From: Simon Davis
Sent: 22 November 2017 12:19
To: Planning.Responses
Subject: FW: BR/289/17/DOC 36 Corbishley Road

2nd Drainage comments

From: Paul Cann
Sent: 22 November 2017 12:18
To: Simon Davis
Subject: RE: BR/289/17/DOC 36 Corbishley Road

Client
Mrs Patricia Paul
Drawing Title
Surface Water Drainage

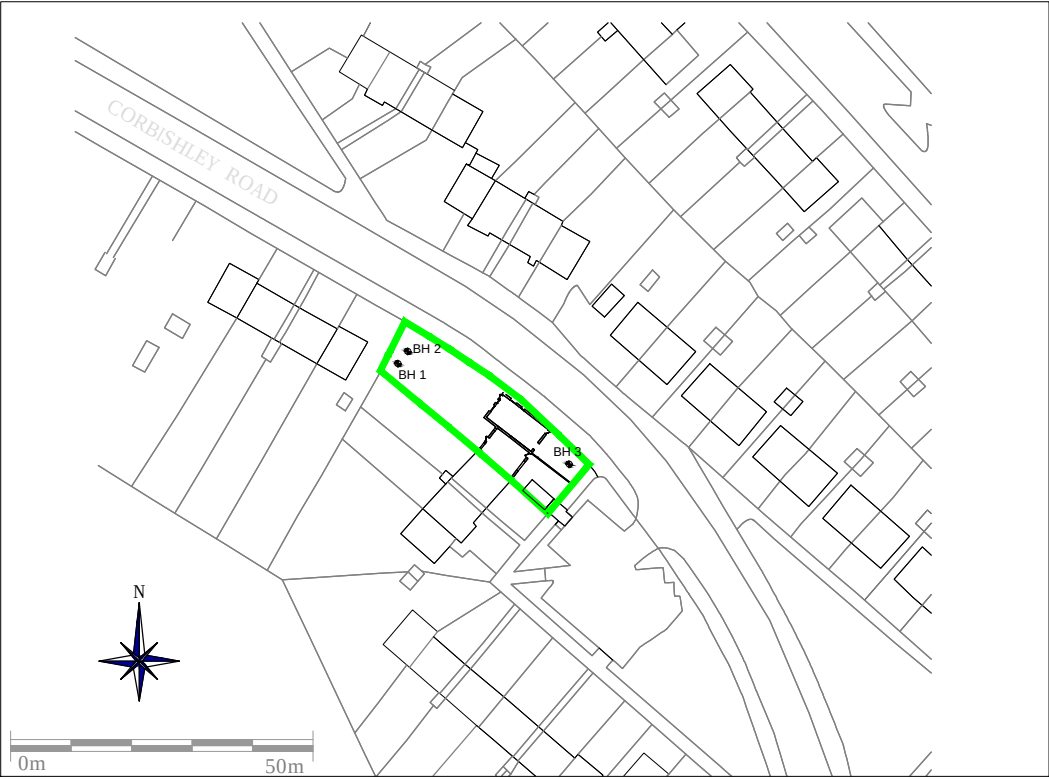
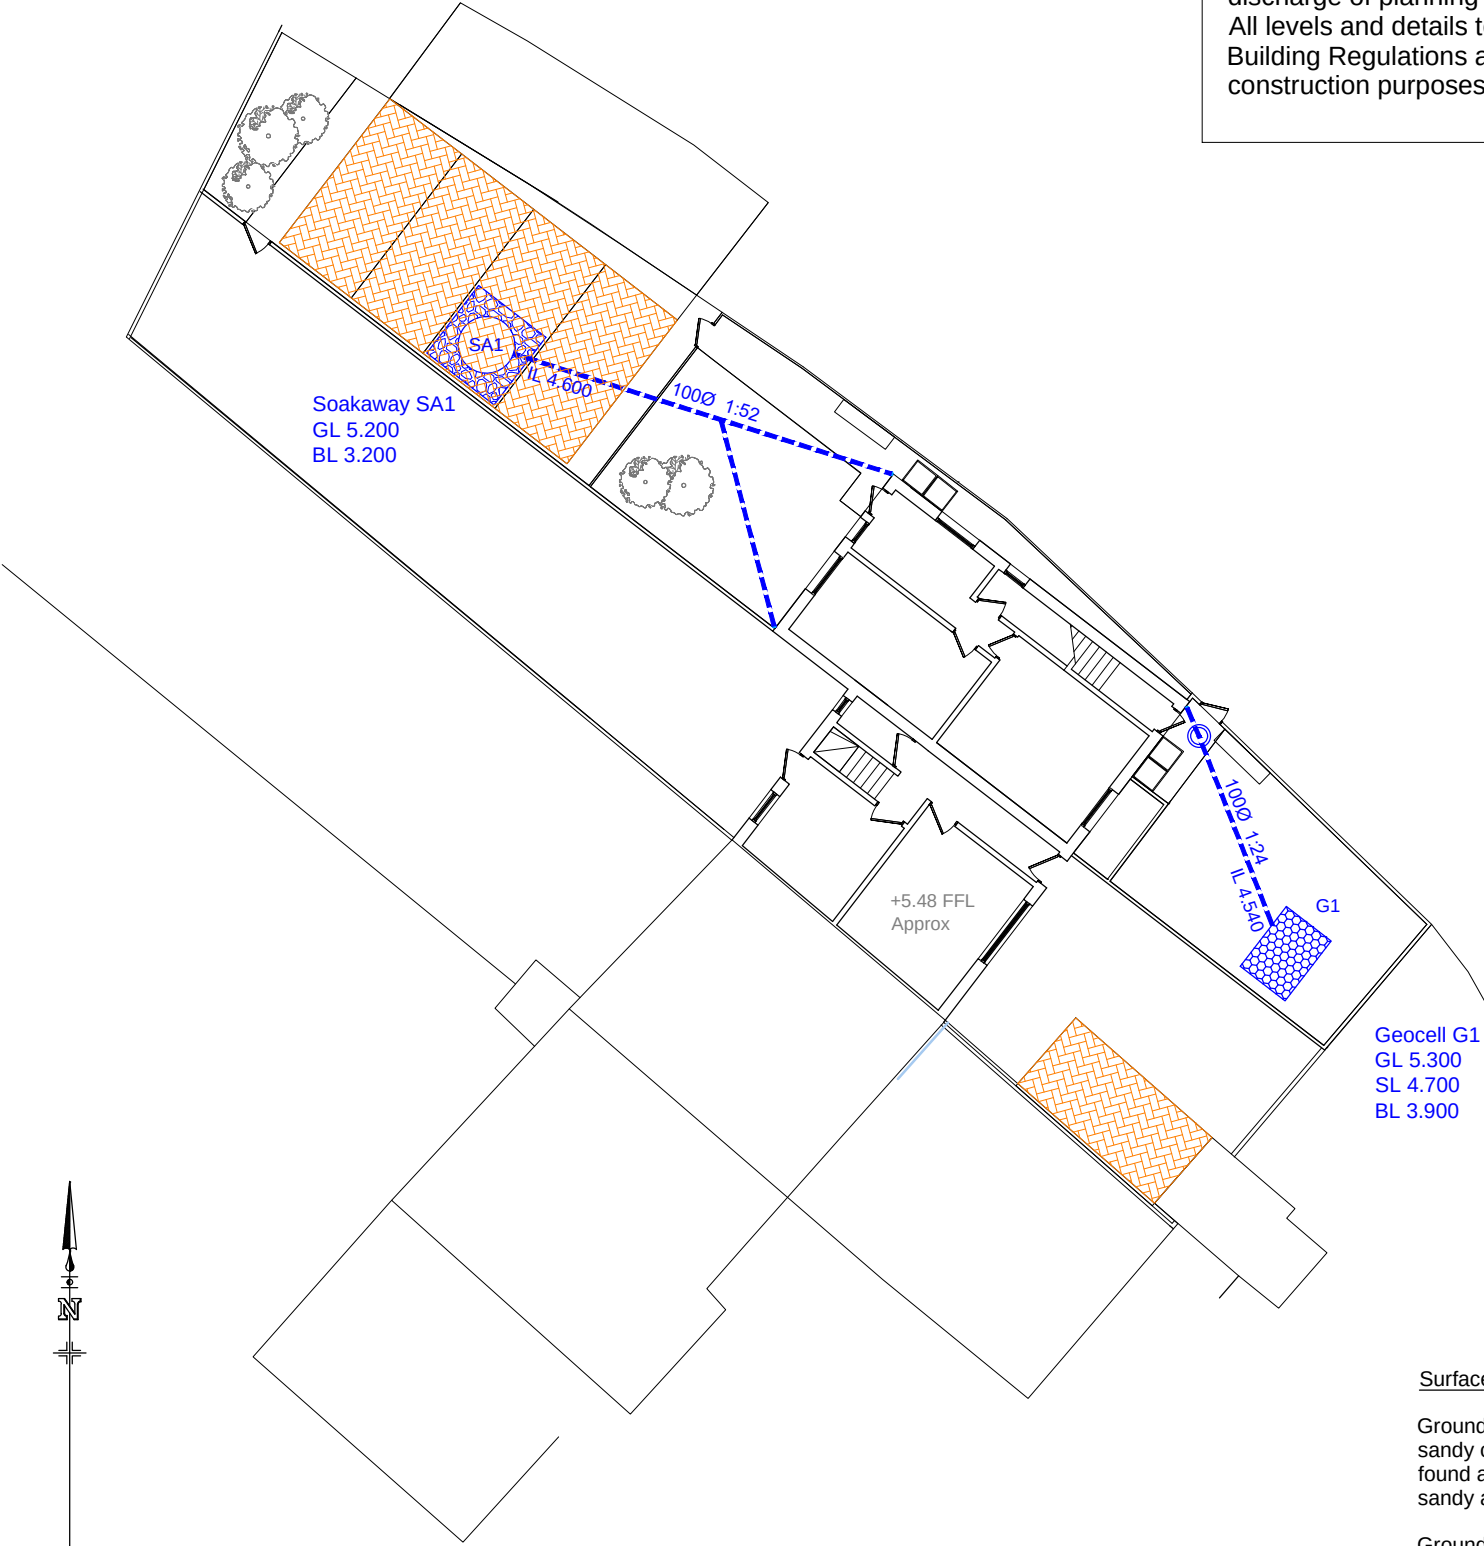
1. The drainage layout needs to include details of the connecting pipes and their levels. It also needs to show how all the impermeable areas are being drained. Silt traps will be required upstream of the soakaway and should be indicated.
2. Detailed construction drawings required for the soakaway/silt traps.
3. Hydraulic calculations are required to prove that the 1 in 100 year storm event + climate change allowance can be accommodated within the drainage scheme/on site.
